Your Ref :
Our Ref : FG/114/18/NMA

Section 96A of the Town & Country Planning Act 1990 (as amended)
Town and Country Planning (Development Management Procedure) (England) Order 2015 (as amended) - Article 10

Application for a non-material amendment following a grant of planning permission FG/147/17/HH relating to reduction in footprint & design of proposed utility to the West boundary & amendments to the ground floor fenestrations
Waters Edge, Florida Road, Ferring,

East Elevation

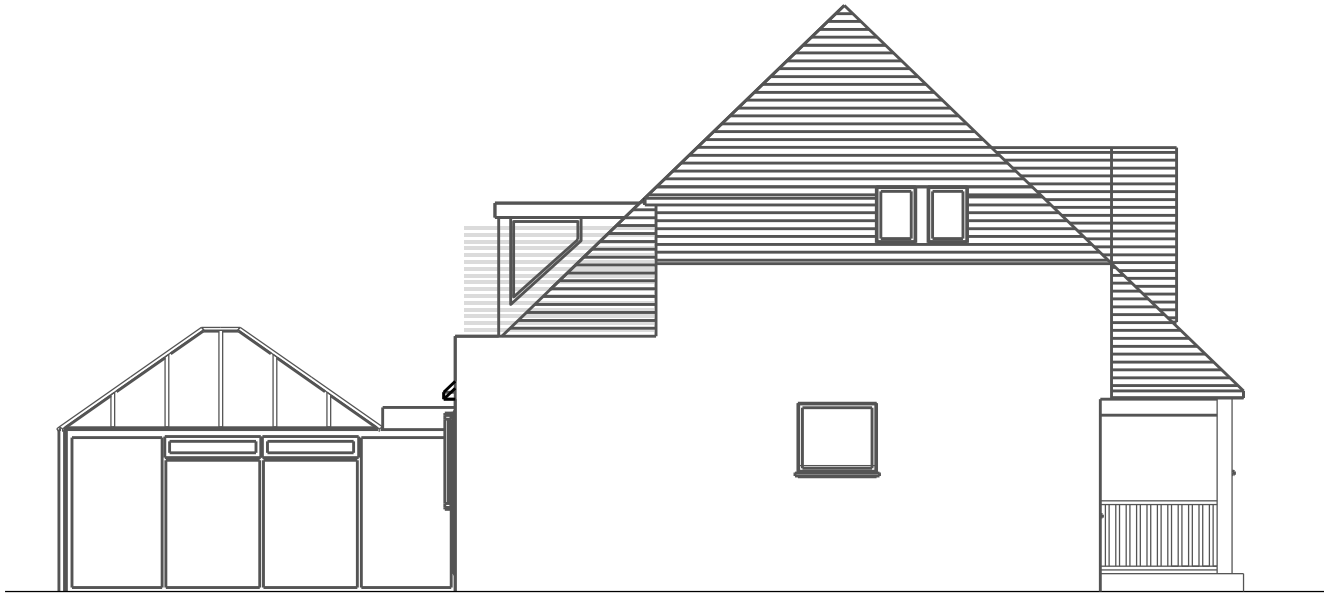
From the information submitted I am unable to take the alterations detailed as a Non Material Amendment to FG/147/17/HH. The form and description of the application do not match the alterations proposed. The first/second floor windows on the east elevation have moved across and are lower down on the roof slope and the dormers have side facing windows. These elements cannot be considered as a Non Material Amendment since they would warrant re-consultation with neighbours.
